# Rezoning Transportation Analysis

Petition Number: 2020-023

General Location Identifier: Tax ID 05321119

Date	Description
03-20-20	First Review
05-27-20	Second Review

RZ-1.0

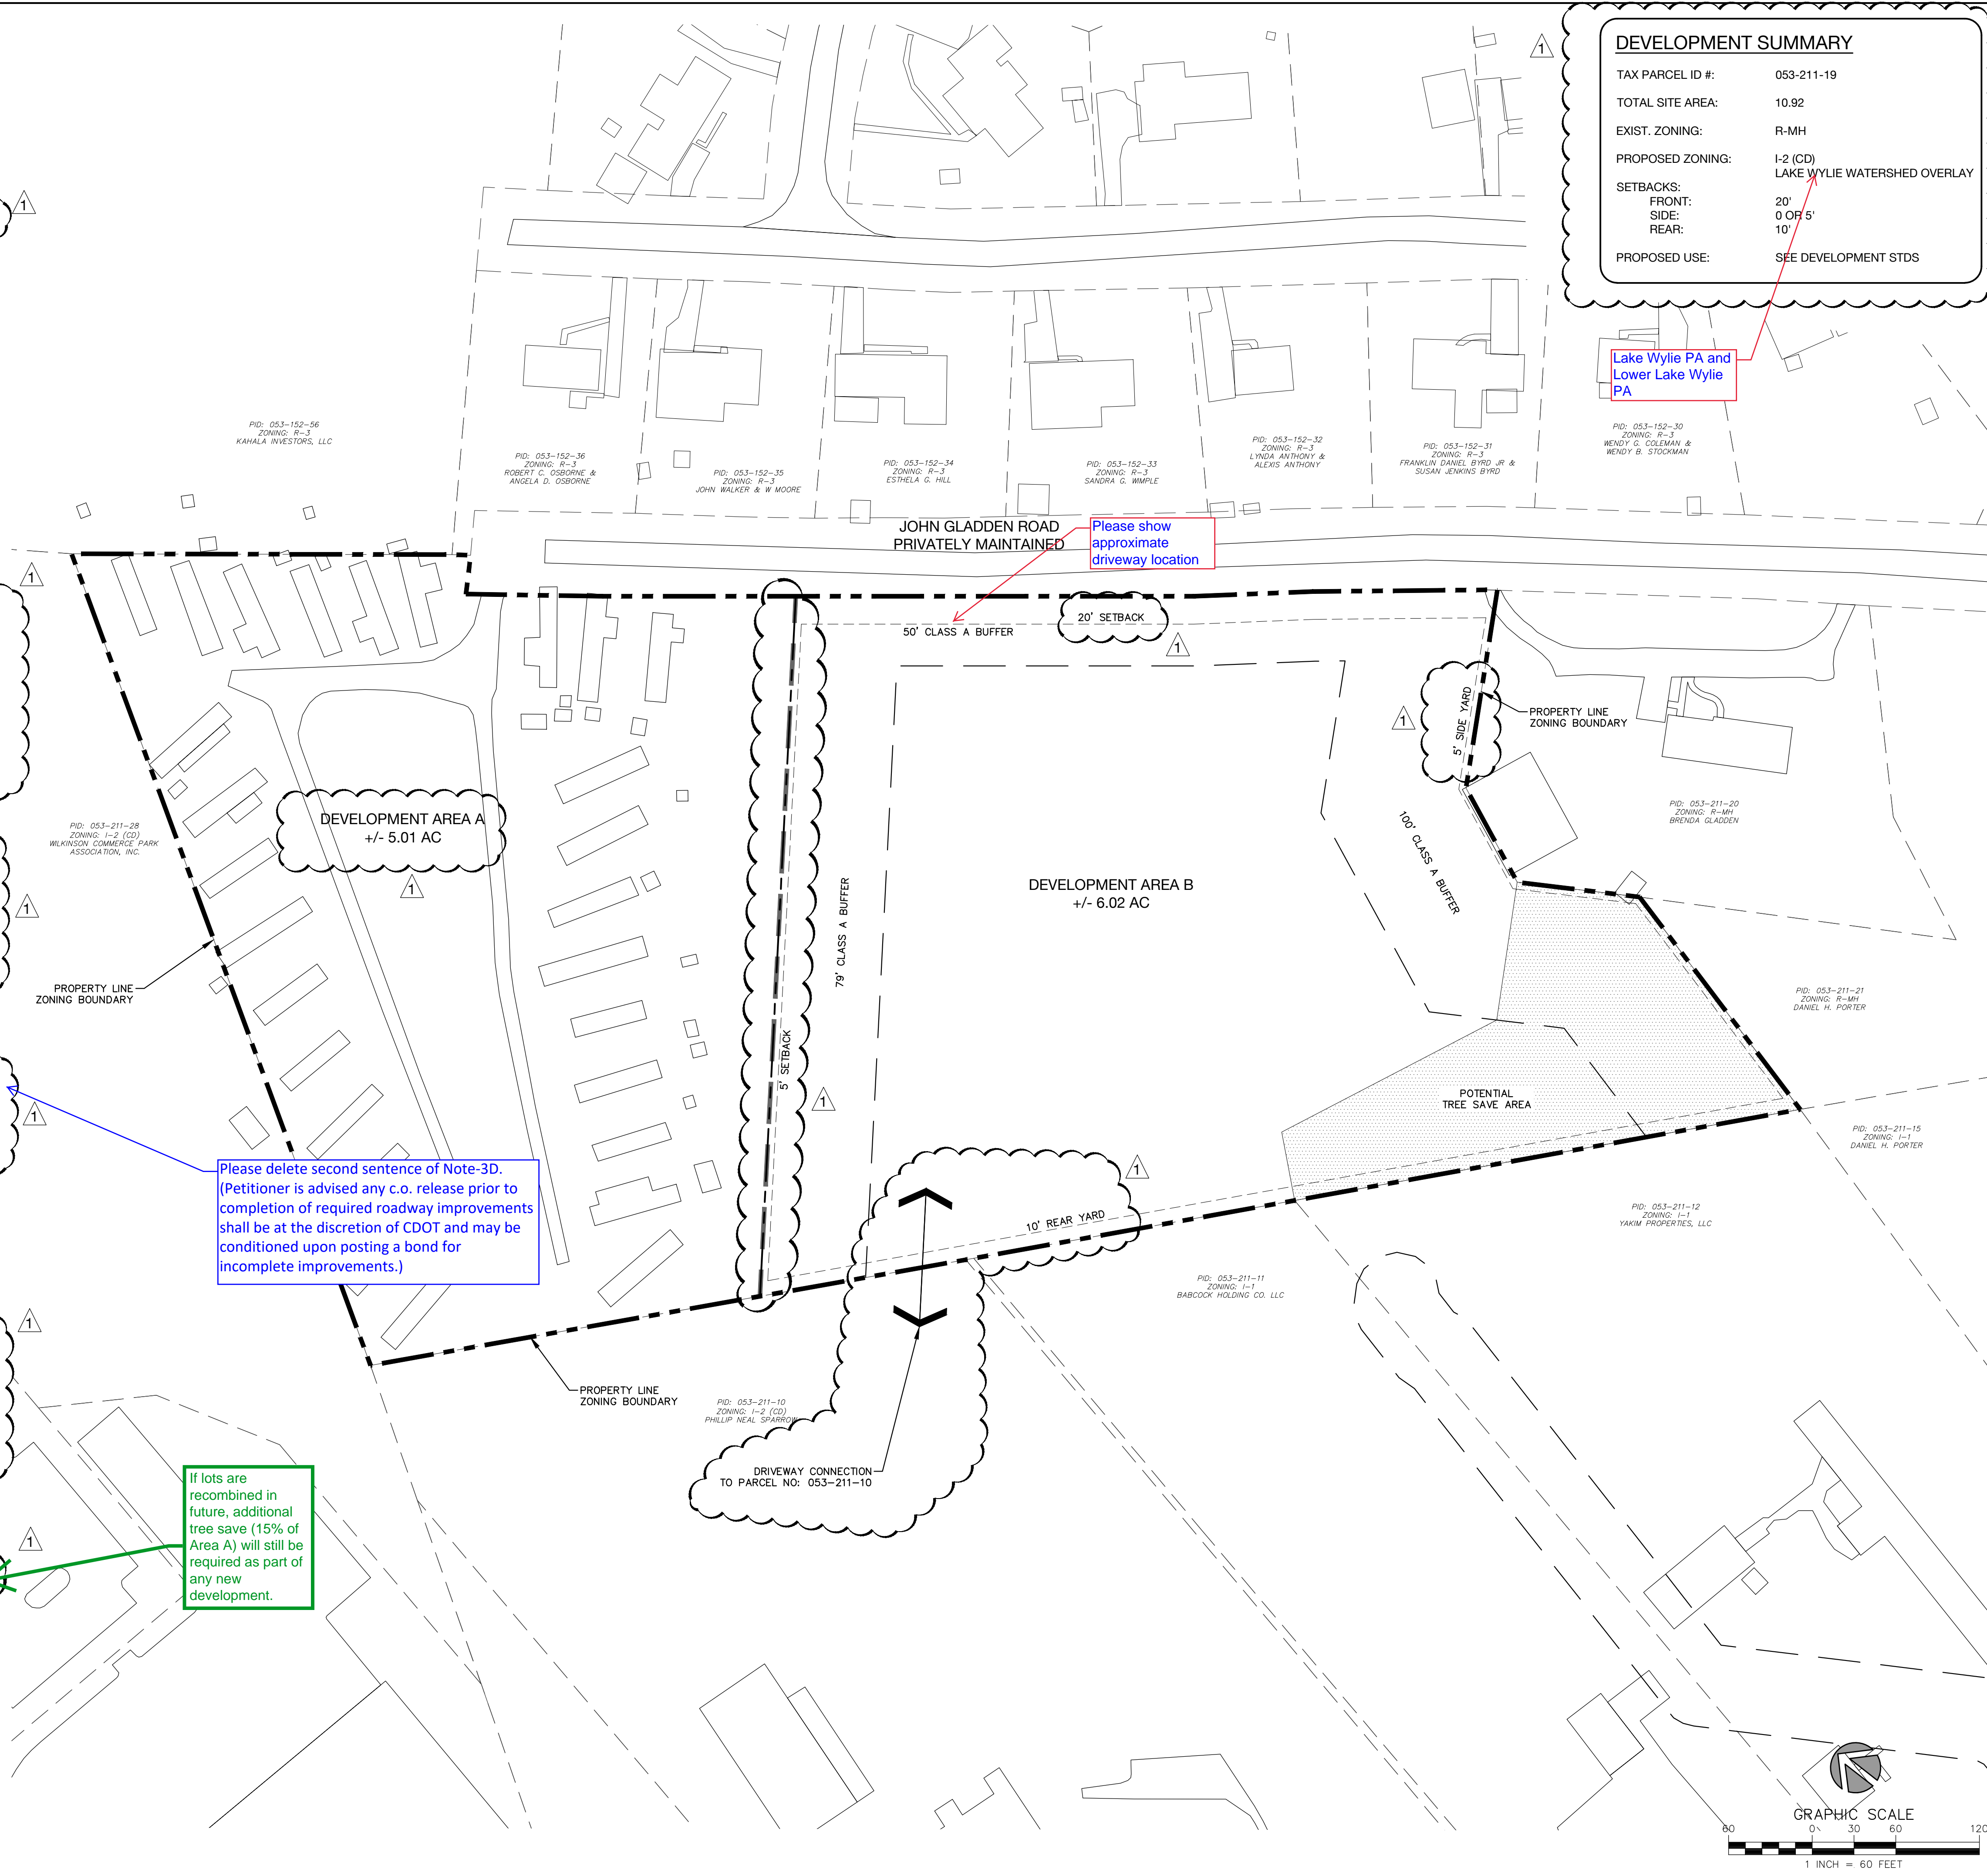
11. **New Comment on revised site plan (05-05-2020)** The petitioner should revise the site plan and conditional notes, in reference to Sections 3.A. and 3.B., to establish and record a cross access easement across Tax Parcel Nos. 053-211-07 and 053-211-10 to Wilkinson Boulevard.

RZ-1.0

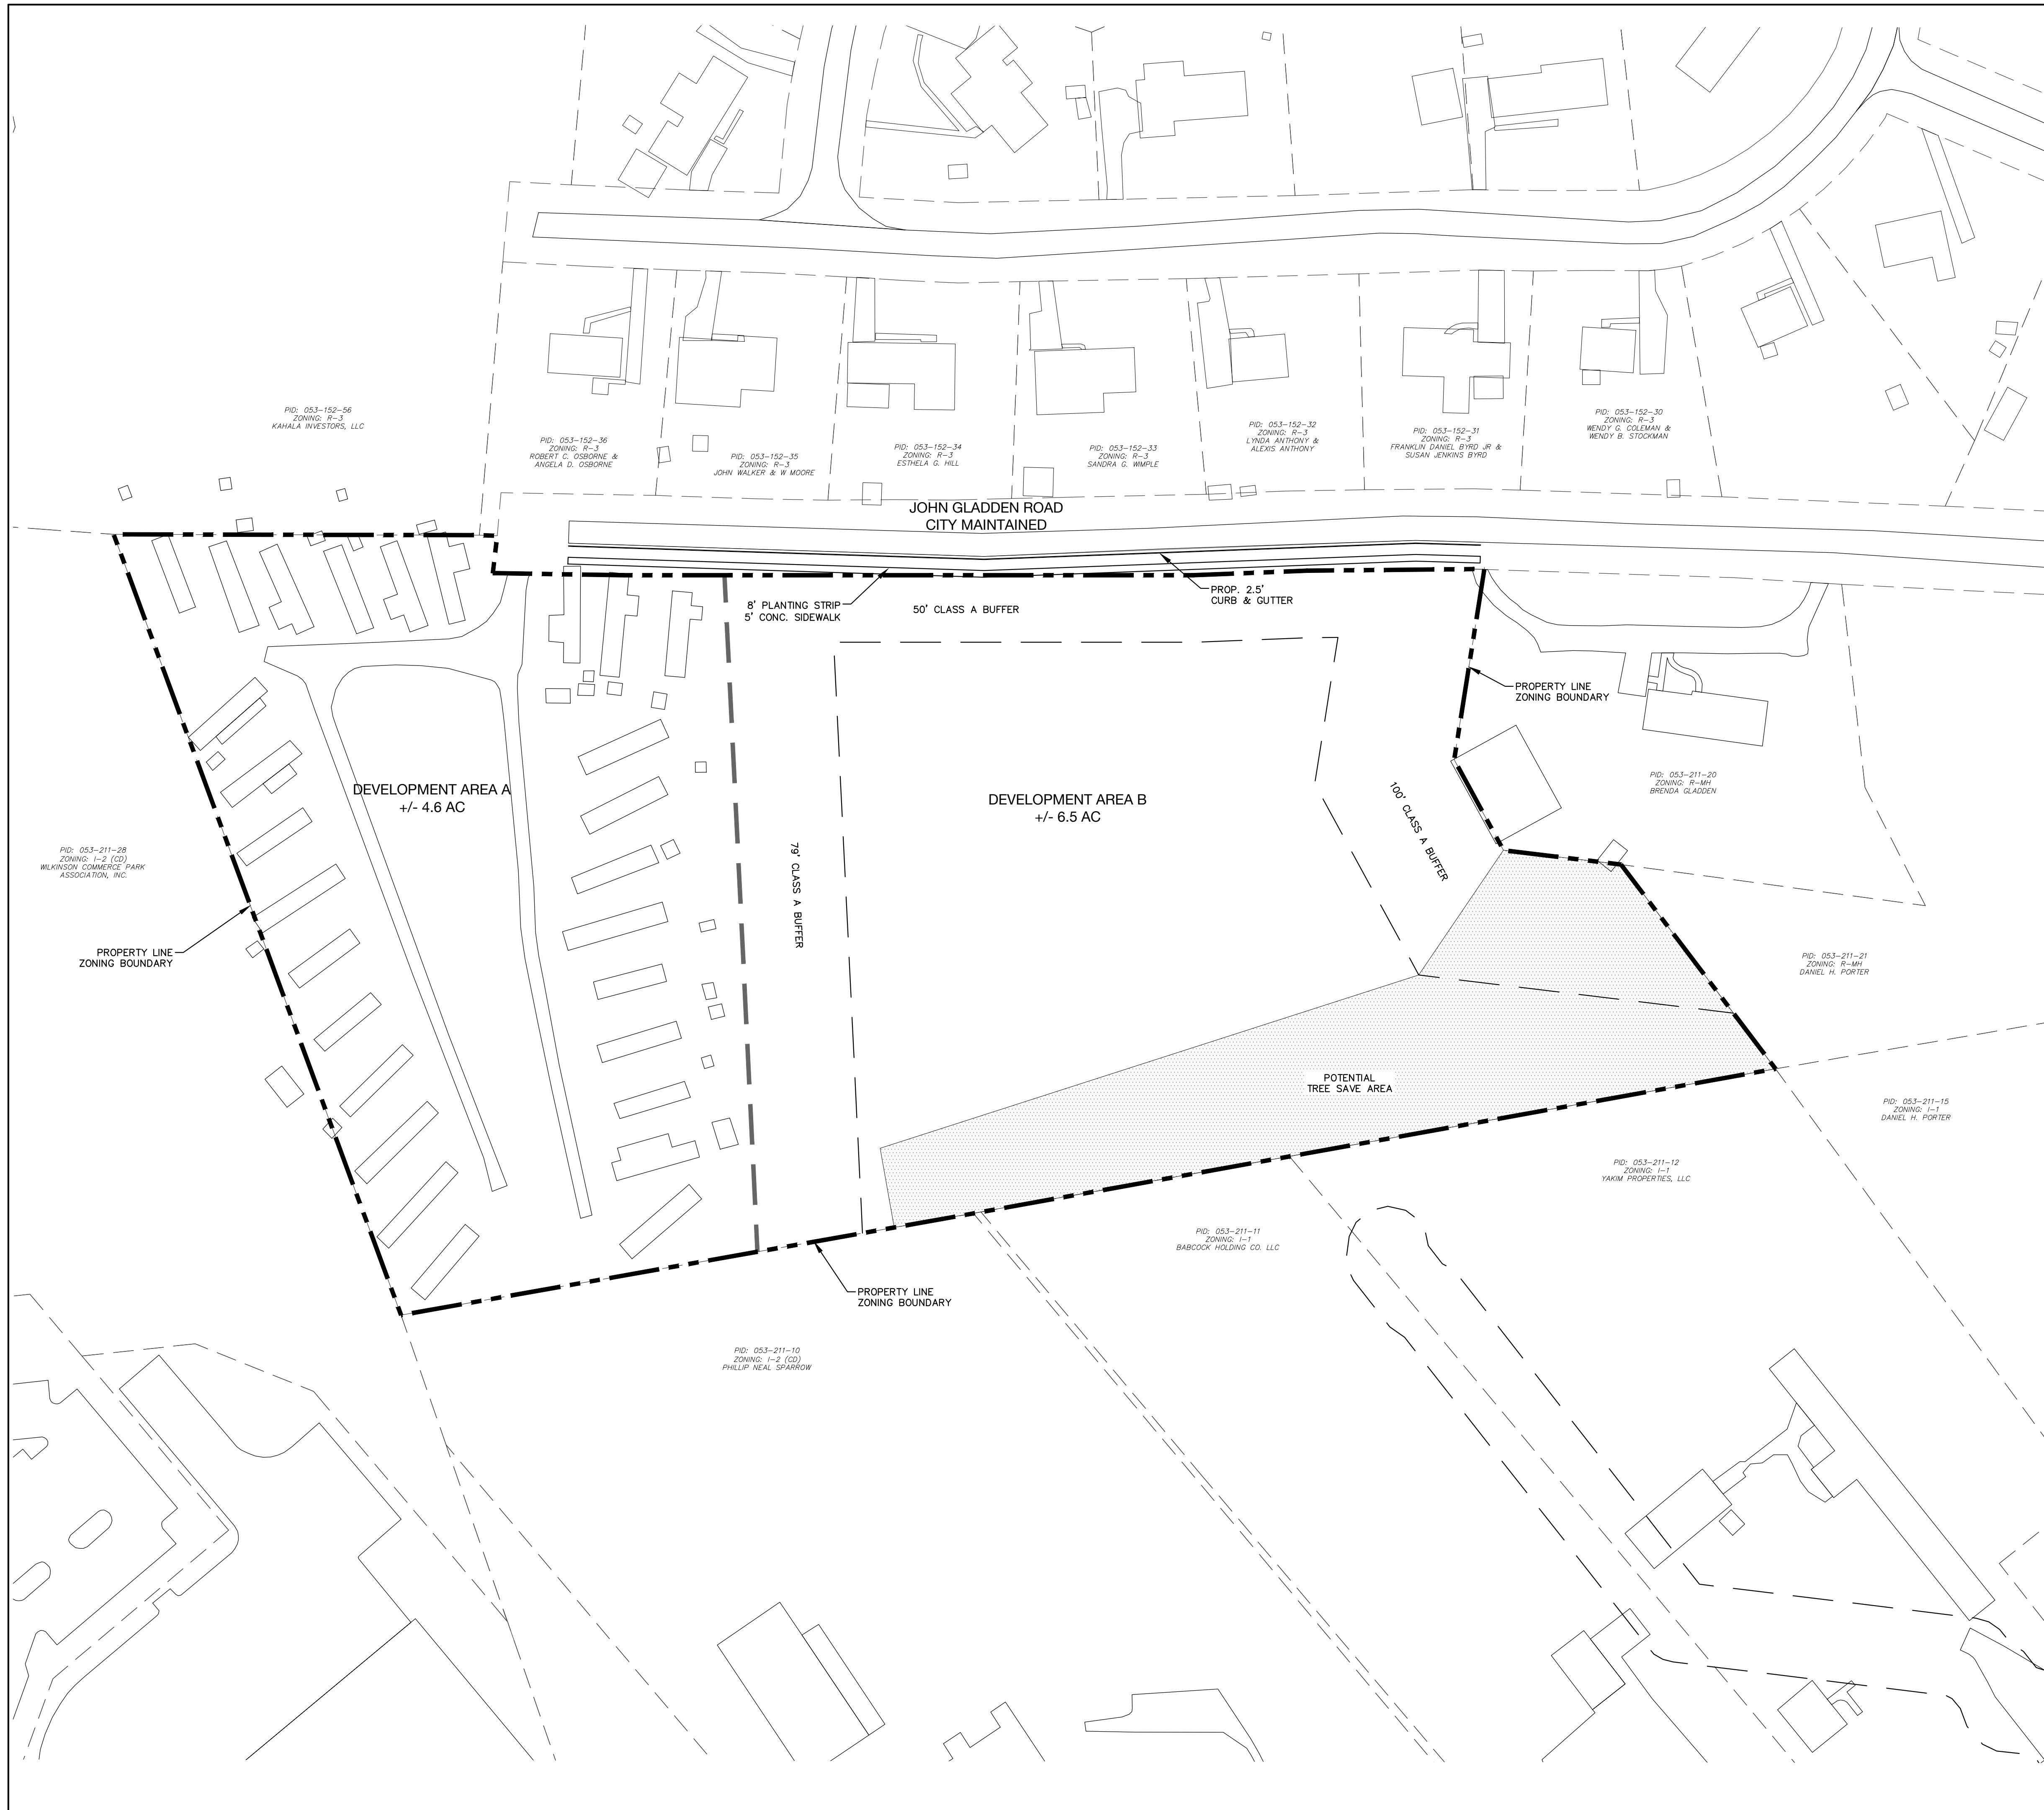
6. If realigning John Gladden Road is necessary, the petitioner should revise the site plan and conditional note(s) to commit to re-striping a left turn lane on Sam Wilson Road, in coordination with CDOT and NCDOT.

7. The petitioner should revise the site plan to remove the "city maintained" label under John Gladden Road. This road is not maintained by NCDOT and may either be privately maintained or unmaintained.

8. The petitioner should revise the site plan and conditional note(s) to include a Subdivision Ordinance required public street, designed per CLDSM std. no. U-06 - Local Industrial Street, as shown below.
